From: John Macholc
Sent: 21 May 2015 15:39
To: Jane Tucker
Subject: FW: Discharge of condition 34 Kirklands chipping

From: Bloomer, David [mailto:David.Bloomer@lancashire.gov.uk]
Sent: 21 May 2015 14:59
To: 'Mike Simpson'
Cc: Ruth Walker; John Macholc
Subject: RE: Discharge of condition 34 Kirklands chipping

Subject: Discharge of condition 34 Kirklands chipping

Client:	KEEPMOAT		
Job:	KIRKLANDS, CHIPPING		
Drawing title:	SITE LAYOUT		
Drawing Number: (Job number)	M3792	100	Revision: C
Scale:	1:100@A1		
Date:	FEB 15		
Drawn by/ checked by:	MCS

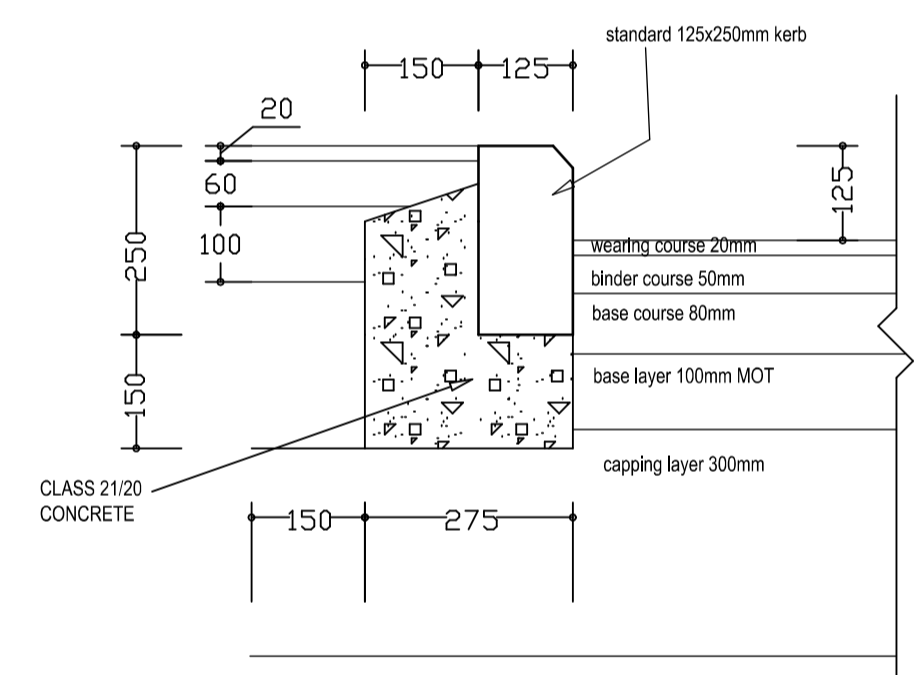
Revised site and landscape layouts amended to suit the comments regarding parking to 34 Kirklands & visibility splay issues and the disabled parking provision and reversing space should the user park over the hatched markings, I trust that these answer your query to your satisfaction.

With regards the parking indicated to 14 Club View, this is outside our site area and the hatching was intended to indicate the area of making good we anticipated needing doing following the construction of the fence lines and retaining structures, it's currently used by this occupant and isn't actually a space designated by ourselves, we've removed the hatch to avoid confusion.

Client:	KEEPMOAT		
Job:	KIRKLANDS, CHIPPING		
Drawing title:	SITE LAYOUT		
Drawing Number: (Job number)	M3792	100	Revision: E
Scale:	1:100@A1		
Date:	FEB 15		
Drawn by/ checked by:	MCS

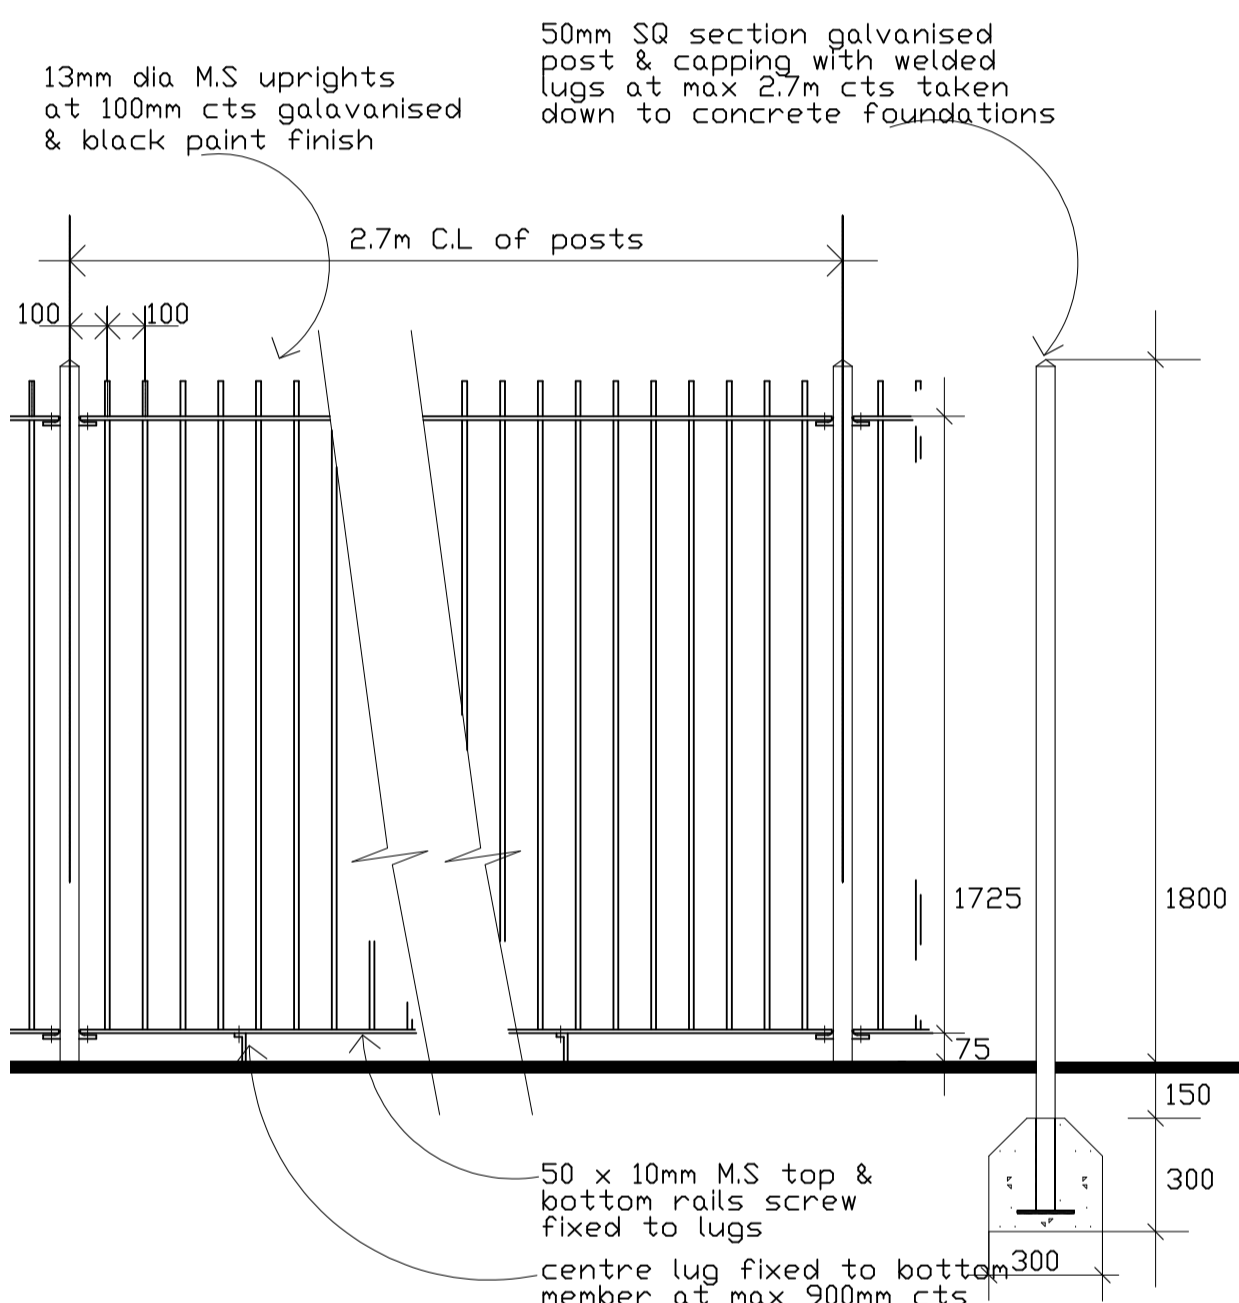
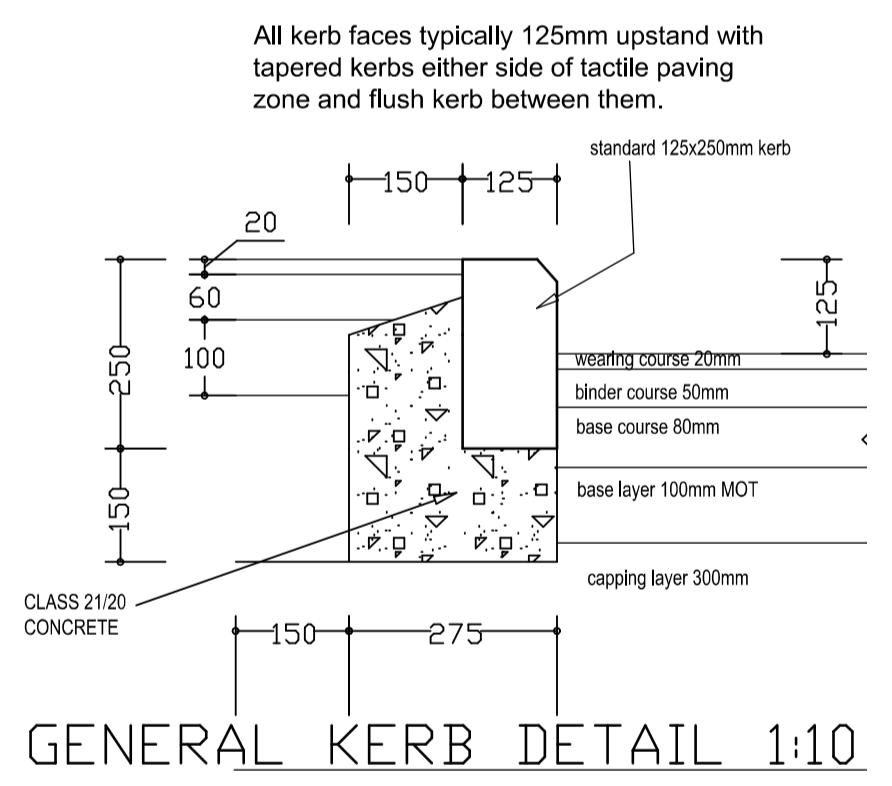
Please find enclosed our revised site layout amended to reflect your comments received via John today, could you please have a look at and let me know today whether you are happy with the revised proposals, I also enclose your letter which we have added comments as before in red. Any query please feel free to contact me or my colleague Ruth Walker at the details below. Please note this is urgent as we want all conditions dealt with in the same application, we have had this with the planning department since end of March.

Afternoon Mike,
The revised plan is acceptable.
